MODIFICATION REQUEST:

***Adaptive Reuse of the Clare Hotel and
Administration Building on Block 3A***

MP 11_0089 - Modification 1

Director-General's
Environmental Assessment Report
Section 75W of the
Environmental Planning and Assessment Act 1979

1 LEVEL 3
1:100

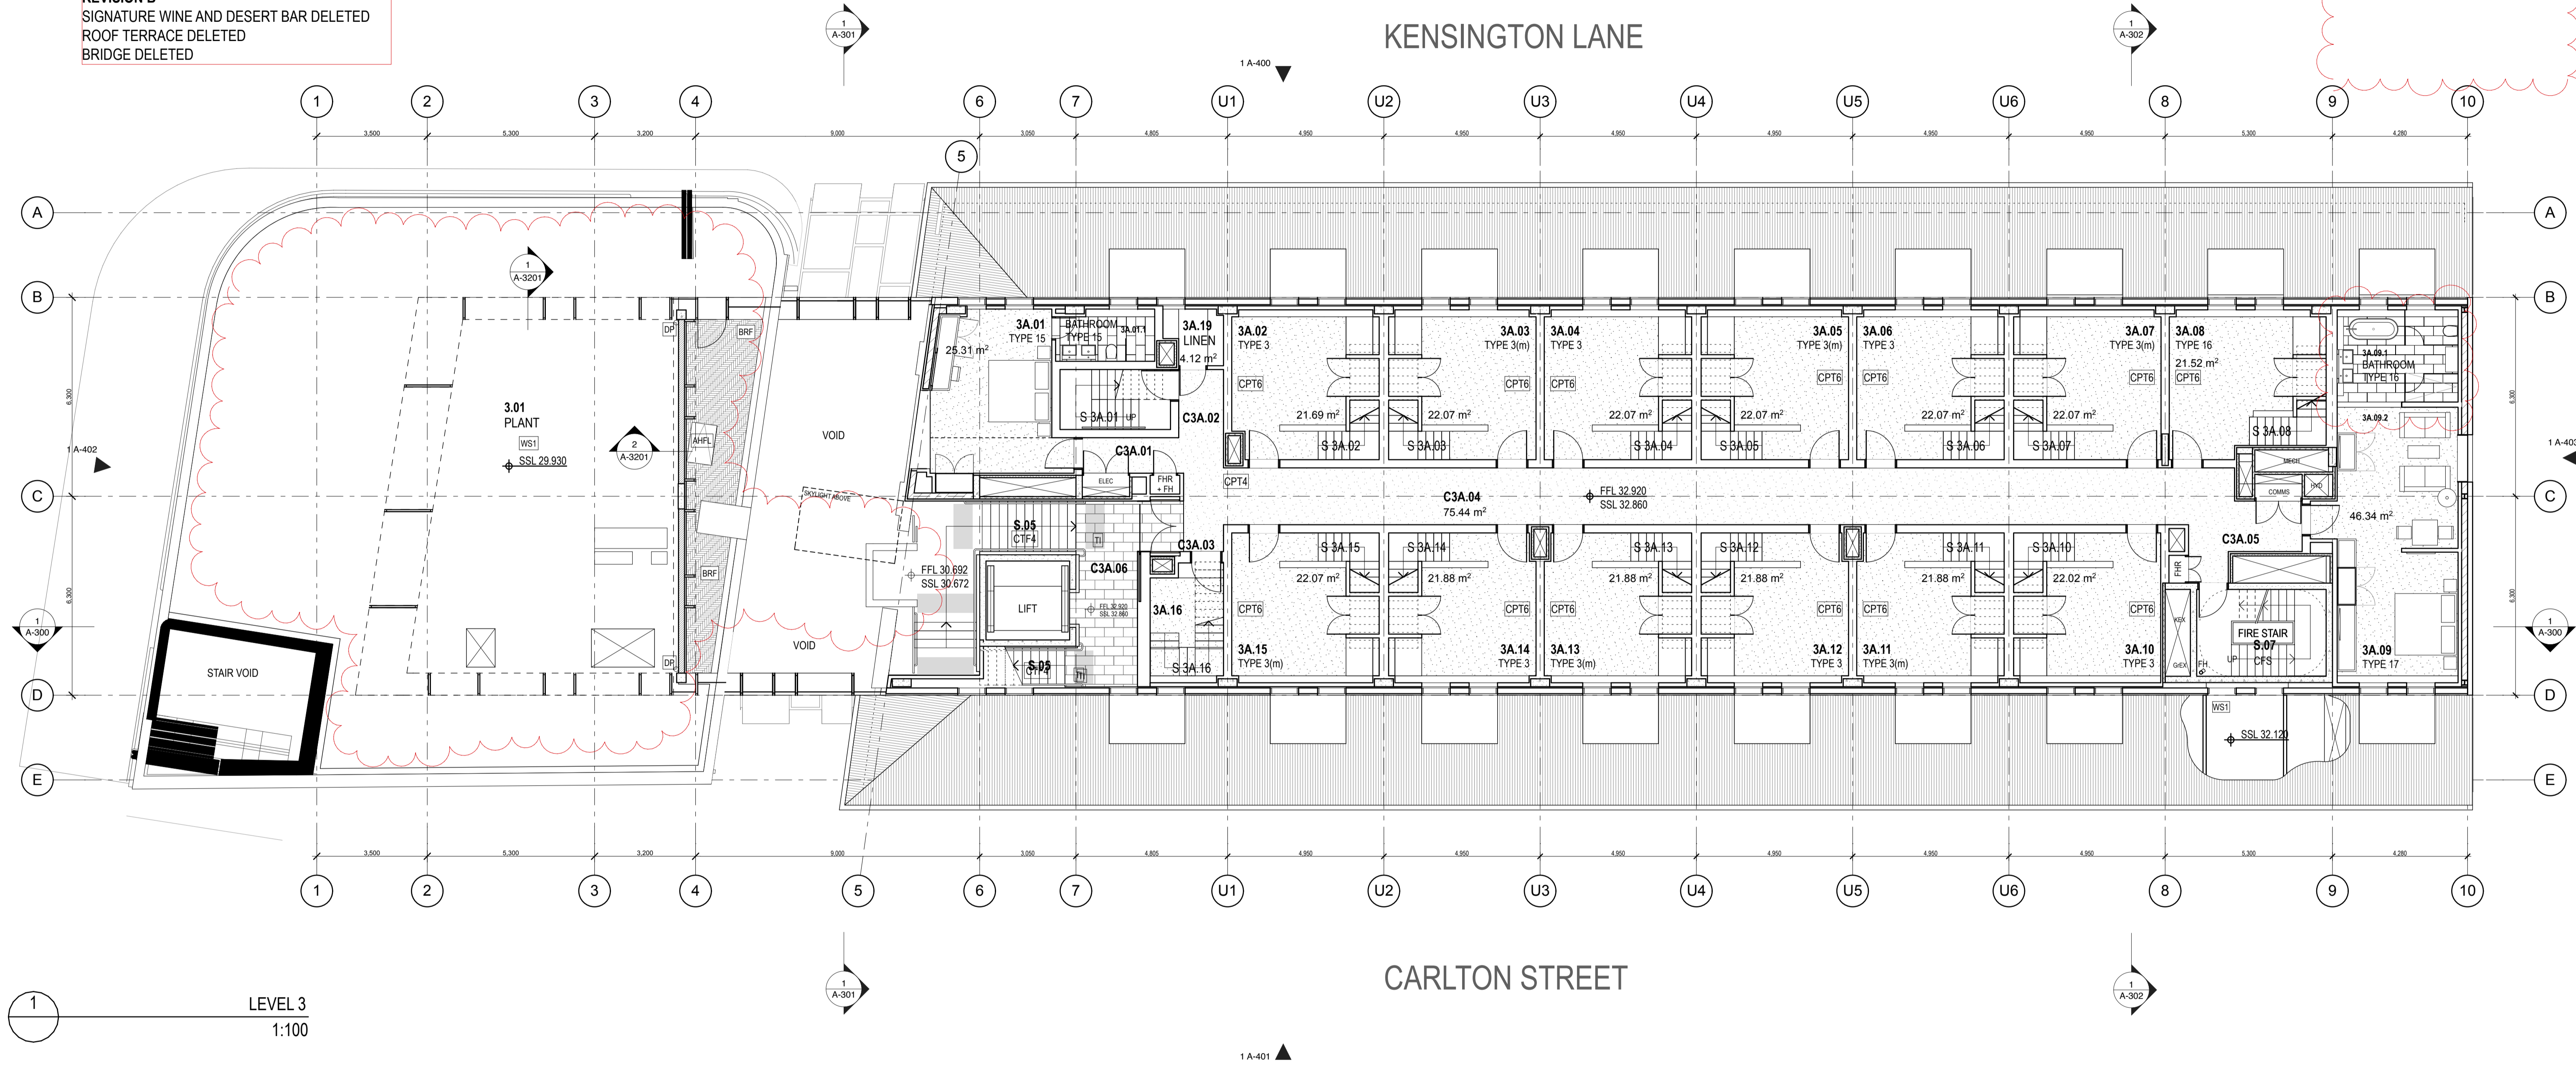
The wine and dessert bar on Level 3 is to be deleted as part of the proposal and the department raises no concern as it is an internal design change that results in no additional environmental impact.

The approved project included construction of a through link bridge between the existing Clare Hotel building and the Administration Building. The proposal seeks to delete this link bridge at Level 3, (see **Figure 2**). In the project approval the department noted the link bridge to be the main external impact to the existing buildings at street level. As the removal of the bridge link would eliminate this impact, the department does not have any concerns with the deletion of this link.

1 ROOF
1:100

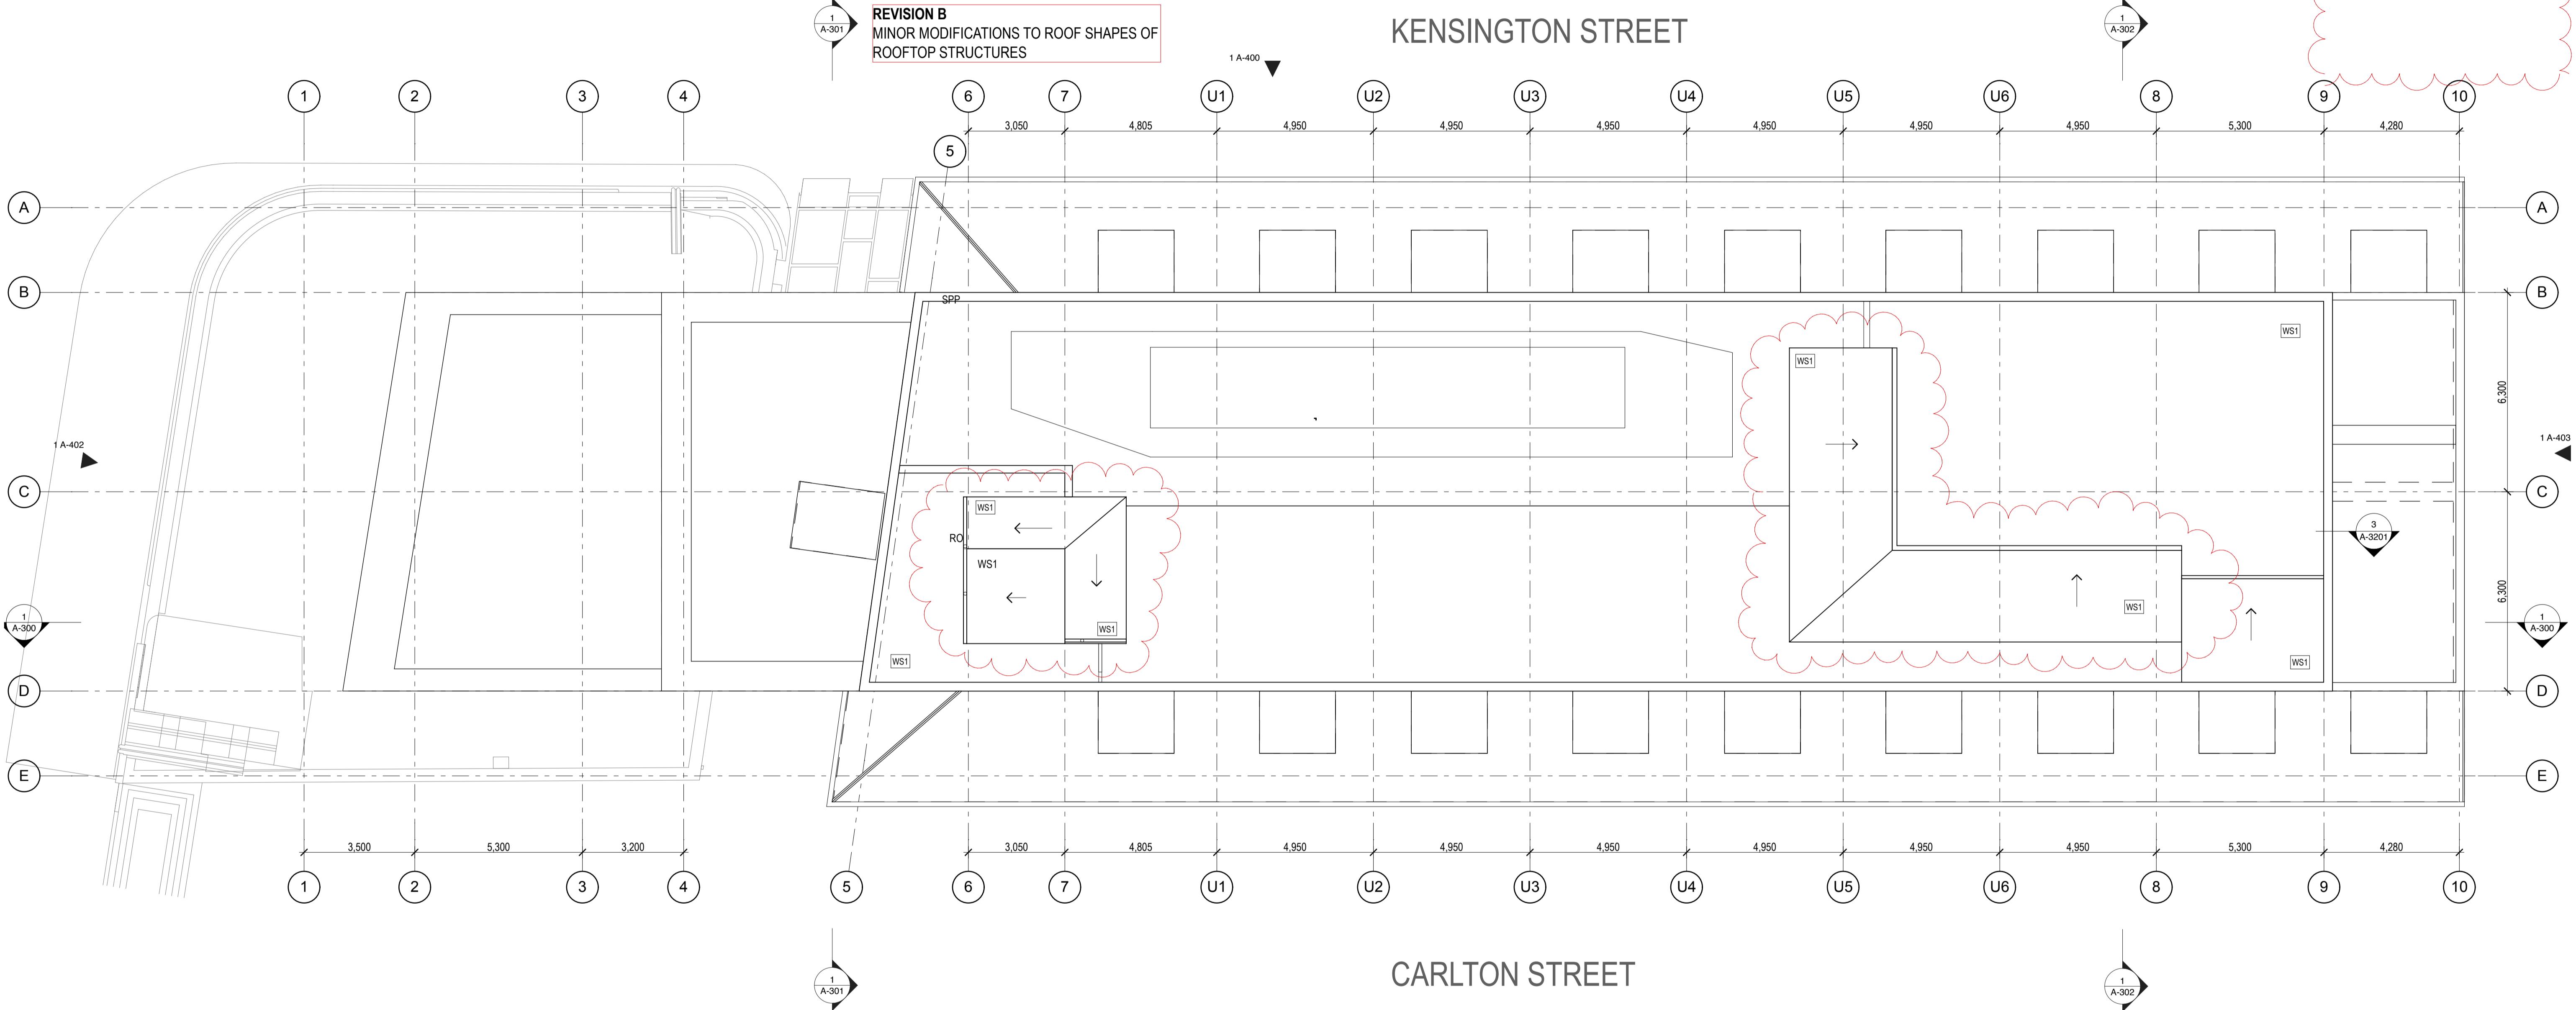
- relocating the pool to the east side of the roof;
- increasing the pool deck roof canopies by 100mm;
- material changes to façade in-fill and lift overrun;
- pattern modified to façade;
- addition of mechanical louvers; and
- alterations to western entry canopy.

1 SECTION 01
 1:100

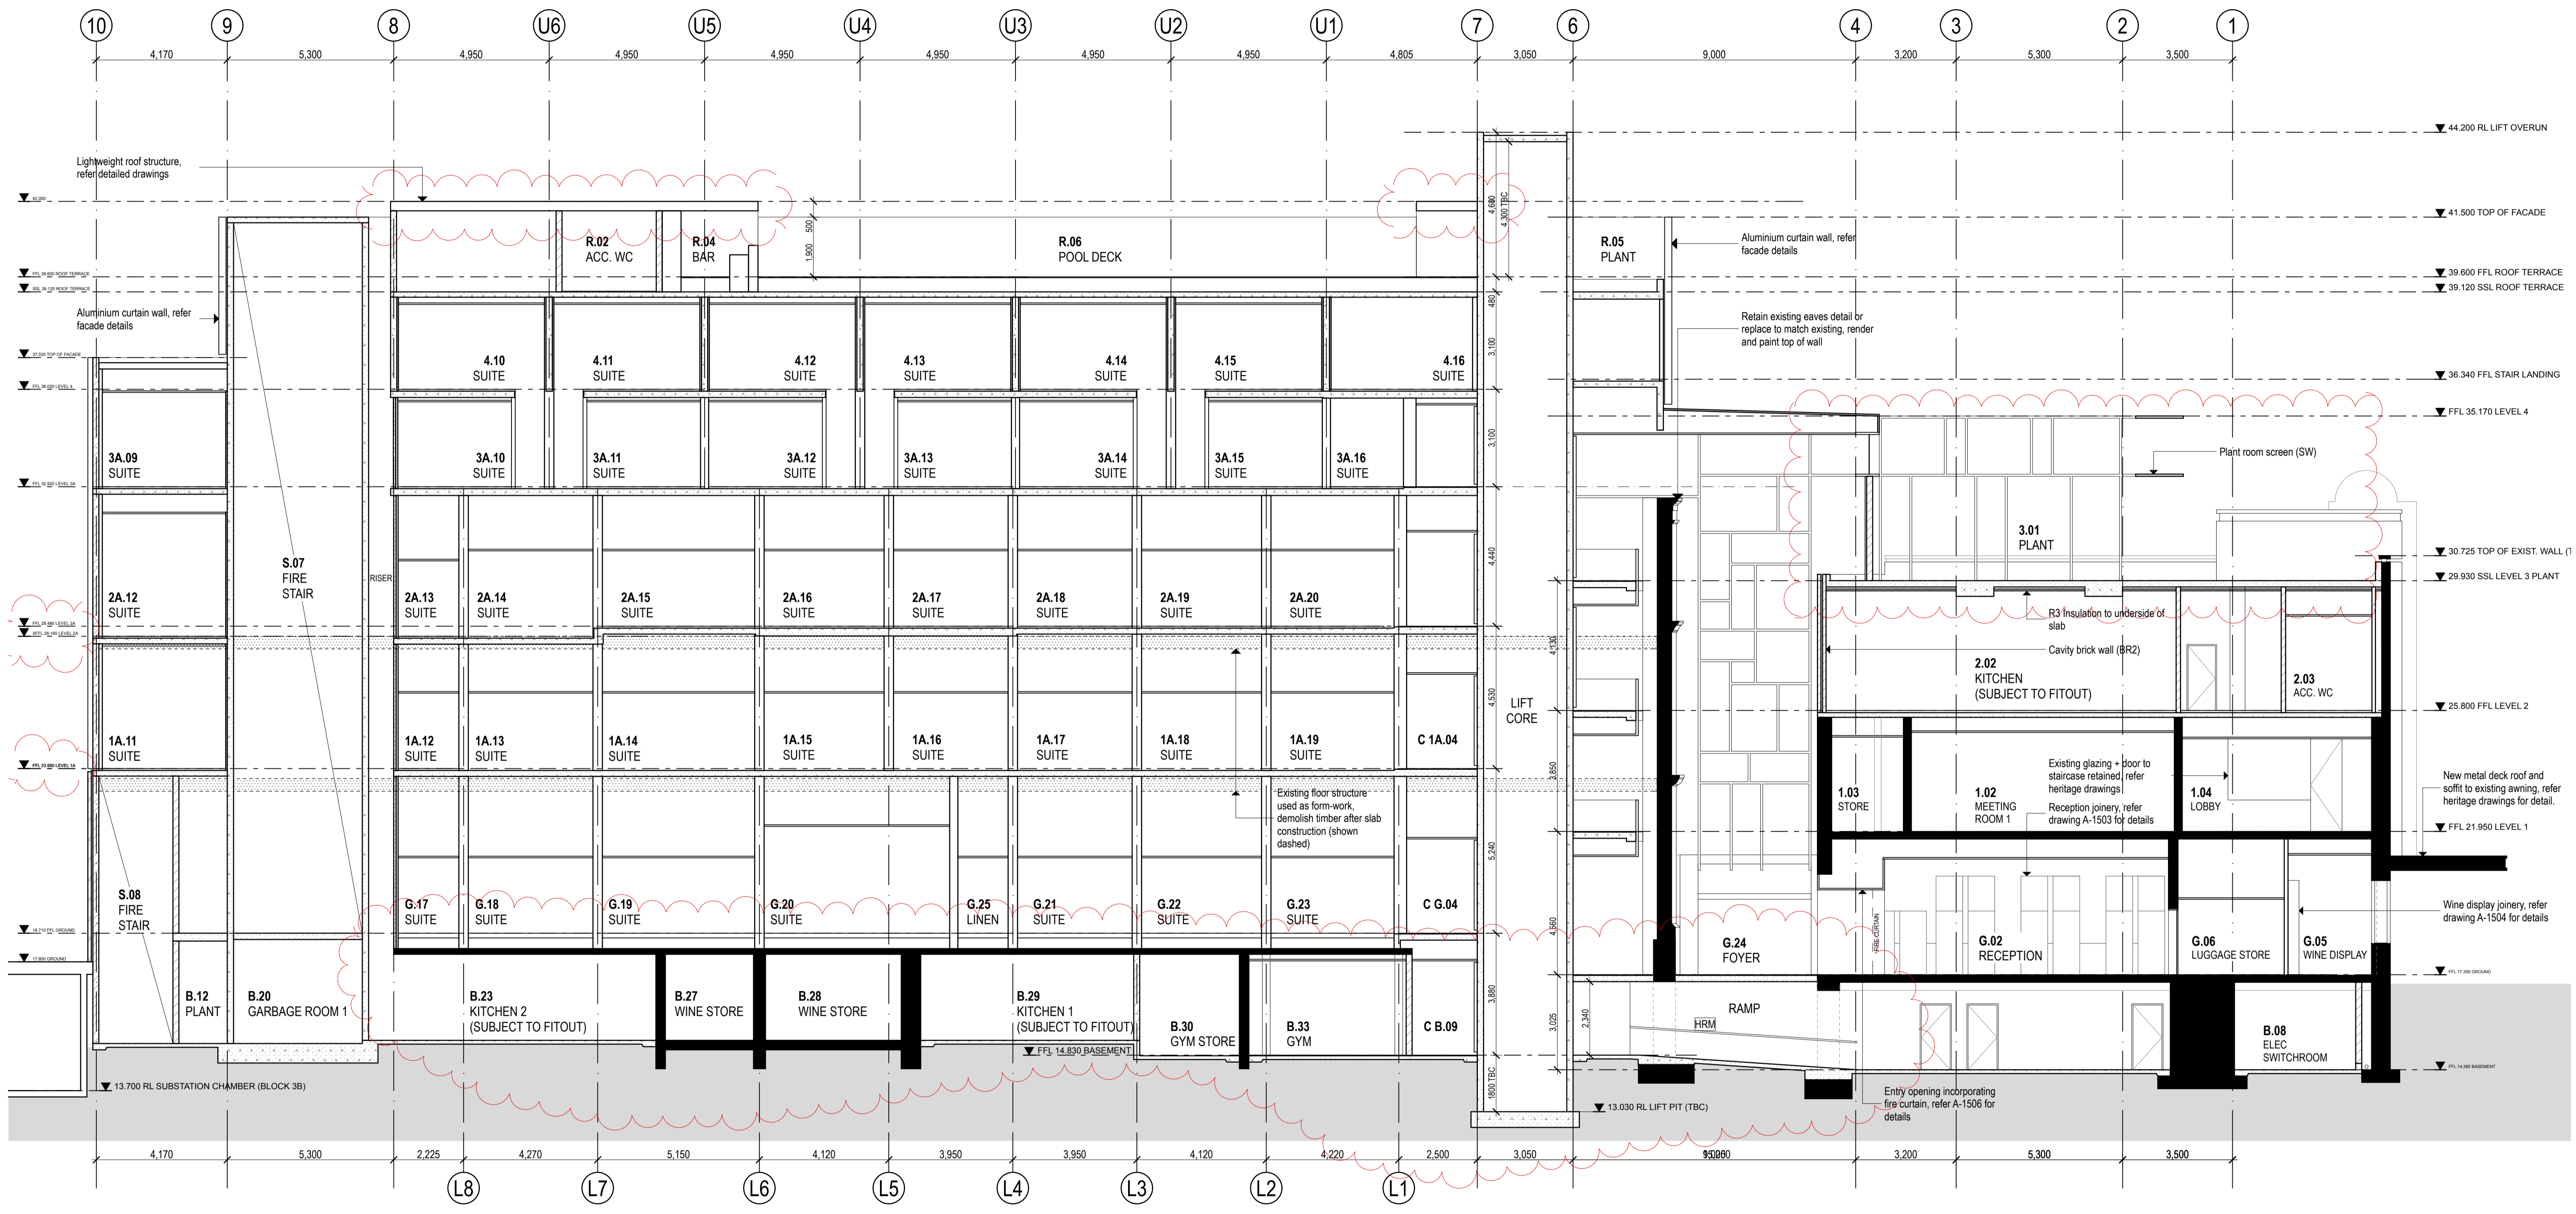
The proposed increase of 100mm to the pool deck roof canopies would change the maximum height of the development from RL 41.9 to RL 42.
